DOC20/58989

Stadium Australia Redevelopment (SSD 10342) Response to Submissions

I am writing to you in reply to the invitation to the Environment Protection Authority (EPA) to provide comment on the Response to Submissions (RtS) for the above project.

Figure 4: Assessment locations and NCAs

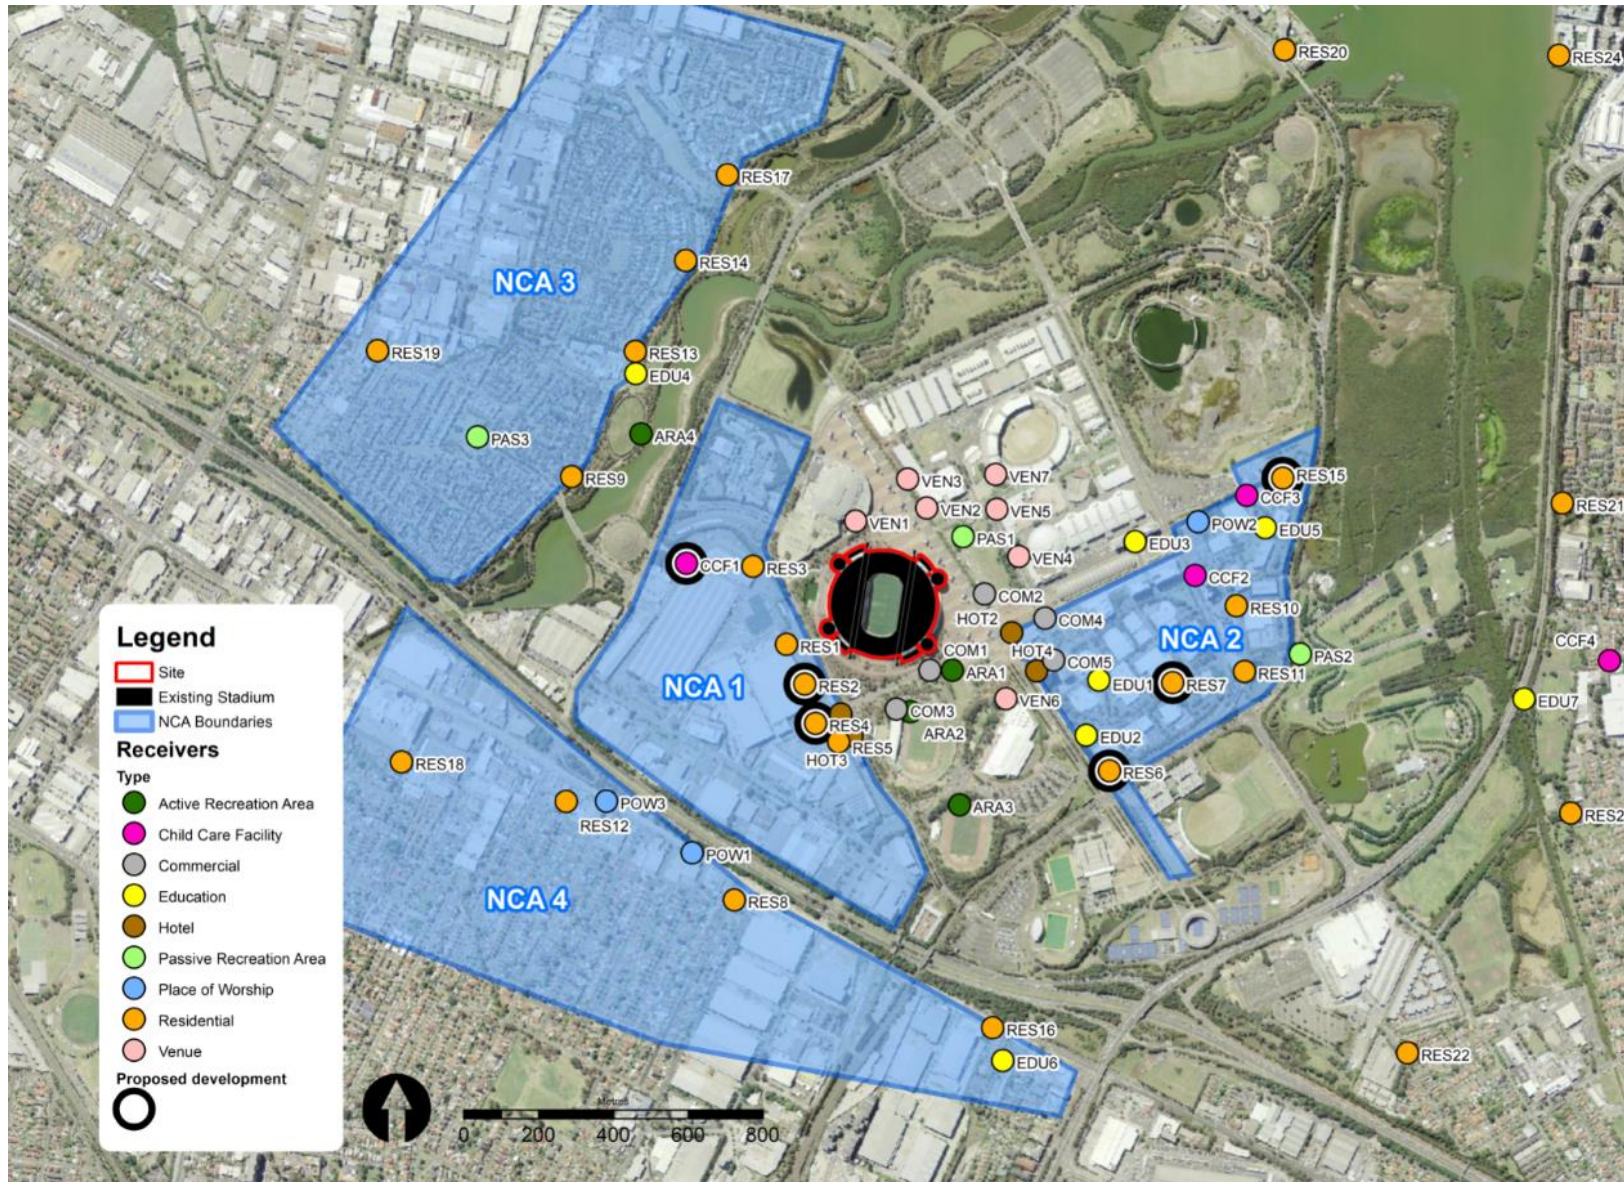
1. Mechanical plant noise generated at the premises must not exceed the noise limits at the times and locations in the table below. The noise limits apply at all residential receivers within the nominated noise catchment area (NCA) in the table below. The area of each NCA is defined in Figure 4 and Table 2 of *Infrastructure New South Wales Stadium Australia Redevelopment SSDA – Noise and Vibration Assessment*, Issue 2, prepared by Arup (dated 04.12.19).

Location – Residential receivers within noise catchment area	Noise limit dB(A)			
	Day	Evening	Night	Night
	L _{Aeq,15min}	L _{Aeq,15min}	L _{Aeq,15min}	L _{Amax}
NCA 1	52	43	38	55
NCA 2	53	43	38	61
NCA 3	47	43	38	56
NCA 4	46	46	43	54
